Charlotte Storm Water  
600 East Fourth Street  
Charlotte, N C 28202-2844

## *Rezoning Petition Review*

**Rezoning Petition #:** 20-84

**Location of Property:** Approximately 9.09 acres located along the west side of Reames Rd, north of Sunset Rd and south of Lawnmeadow Dr.

<p style="font-weight: bold; font-size: small;">RZ-1</p>

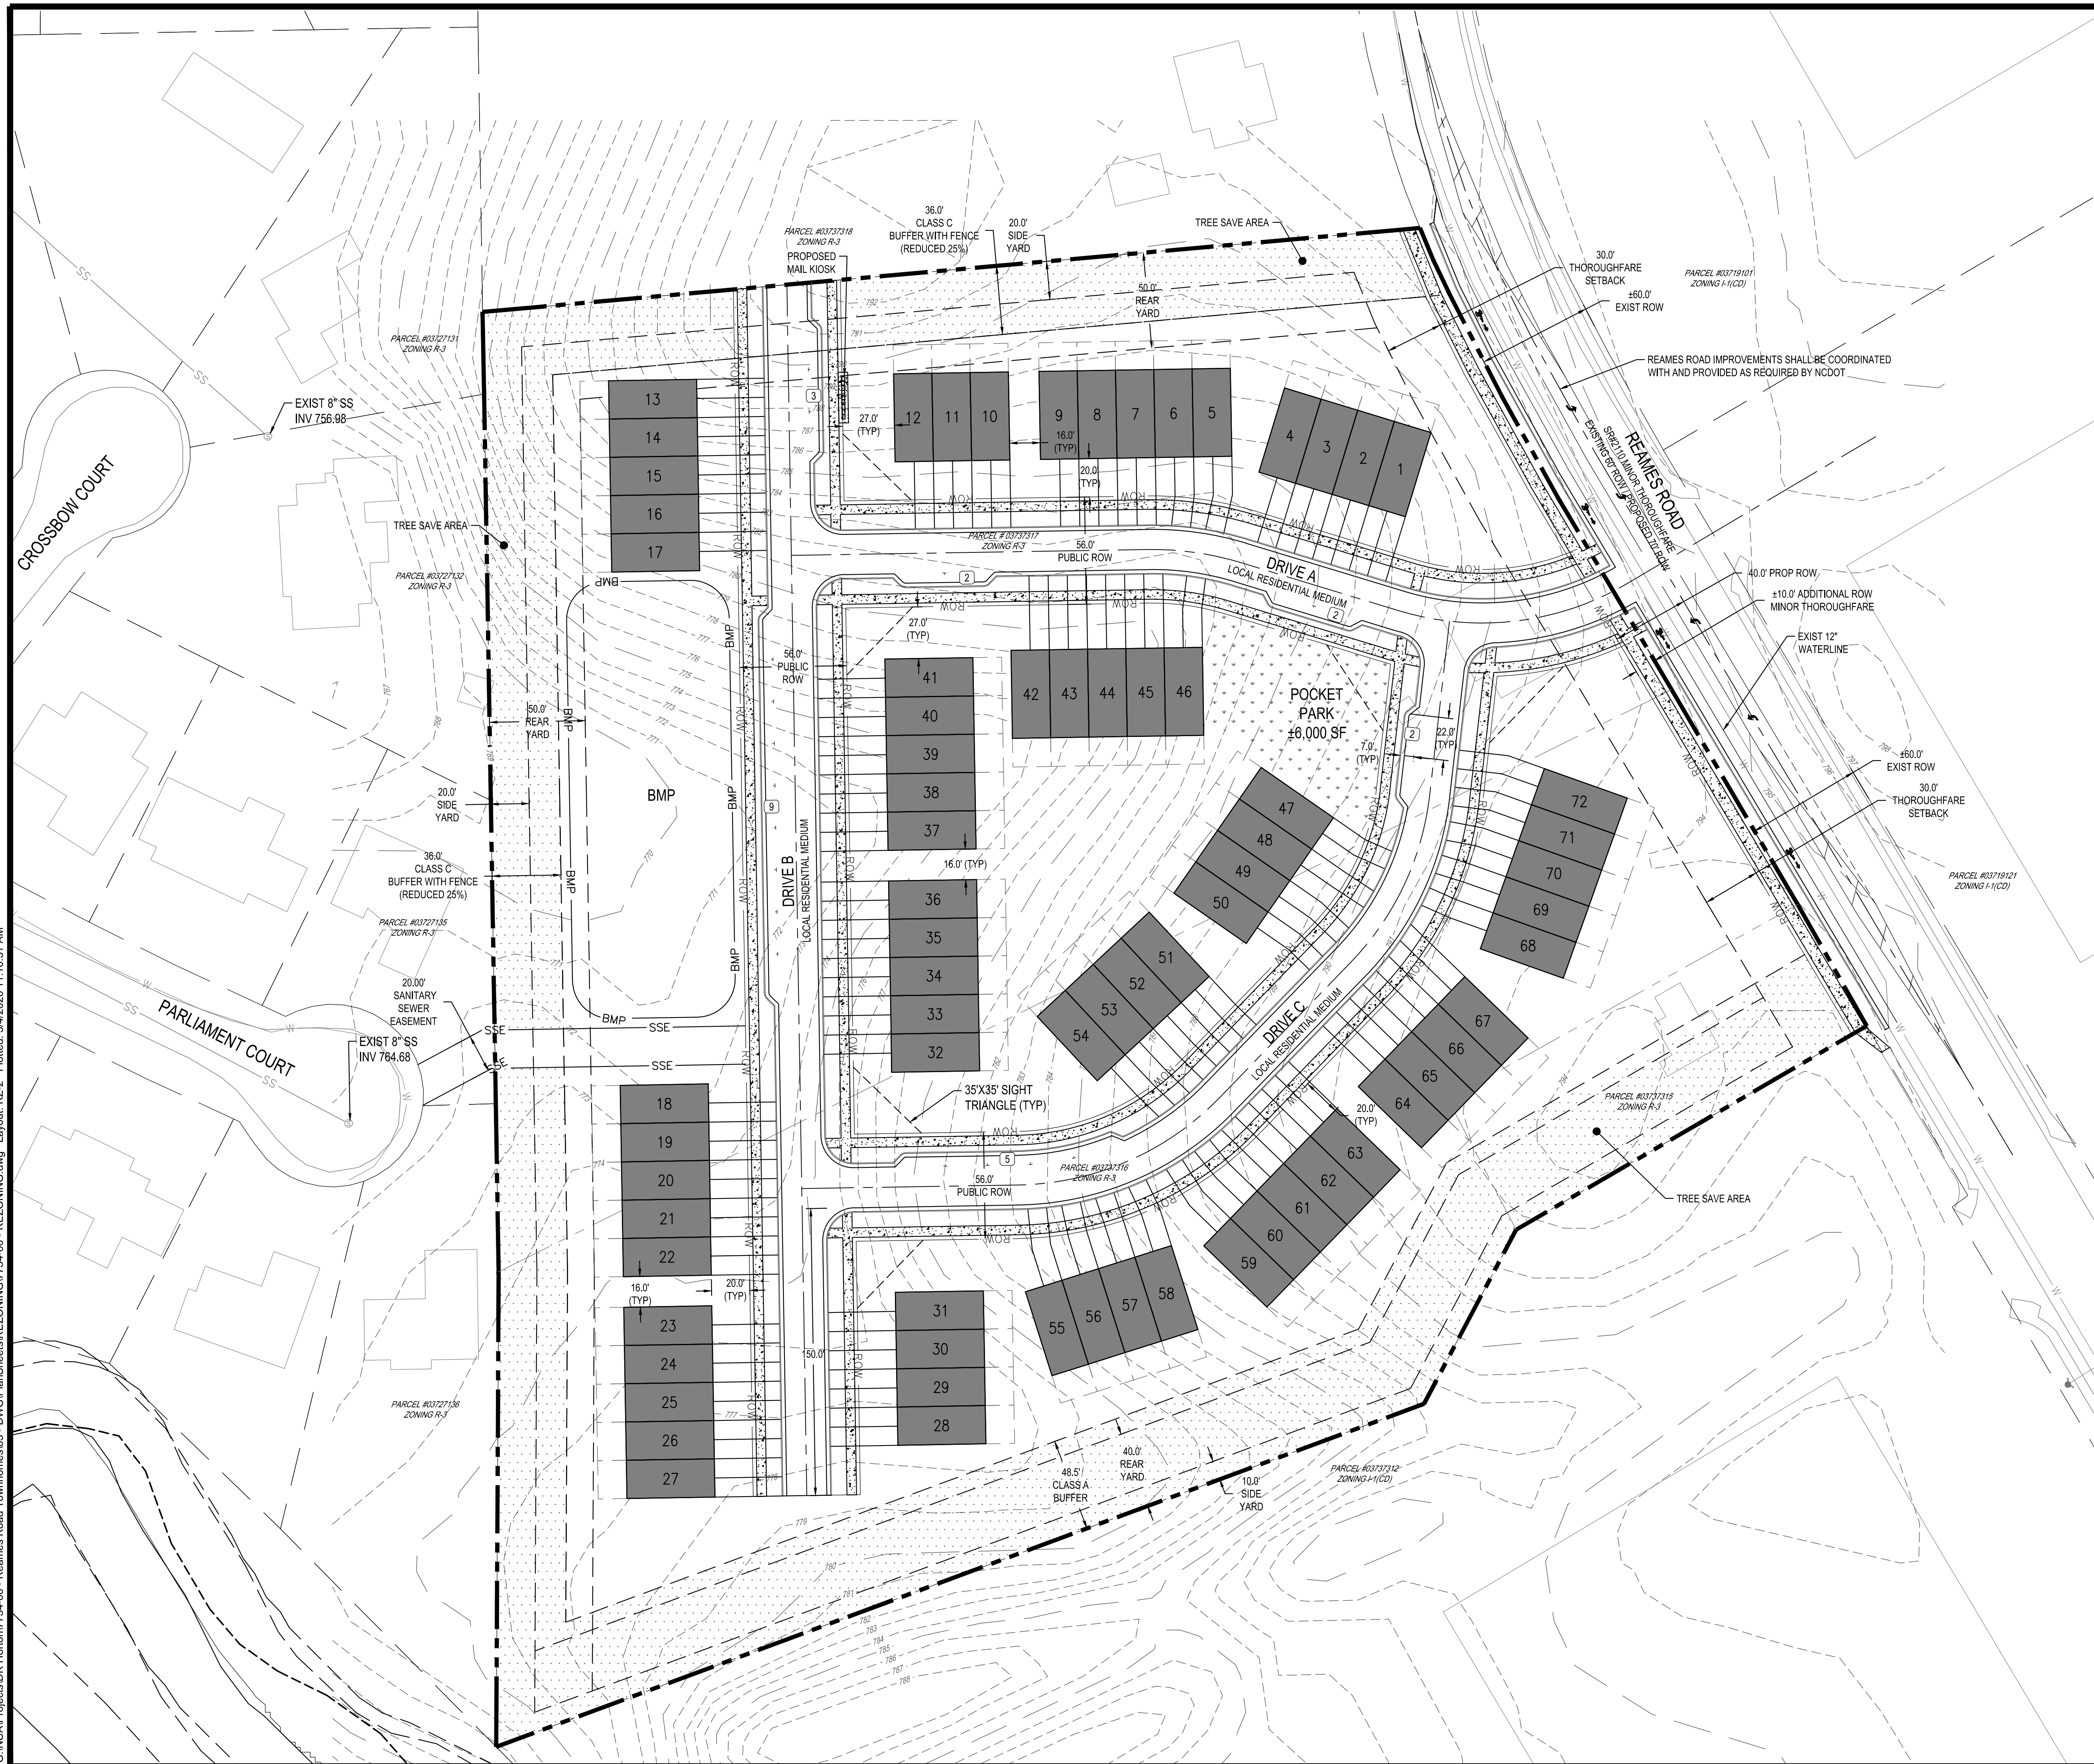
**Concerning Storm Water:** Downstream properties have open Storm Water requests for service. Please include the following note under Environmental Features. *For adjoining parcels receiving storm water discharge the petitioner shall analyze the adequacy of the existing storm water conveyance on the adjoining parcels to the nearest City maintained right-of way. If the existing storm water conveyance on the adjoining parcels is found to be inadequate, the Petitioner shall make a good faith effort with the property owner(s) to improve the storm water conveyance or mitigate the storm water discharge onto the adjoining parcels.*
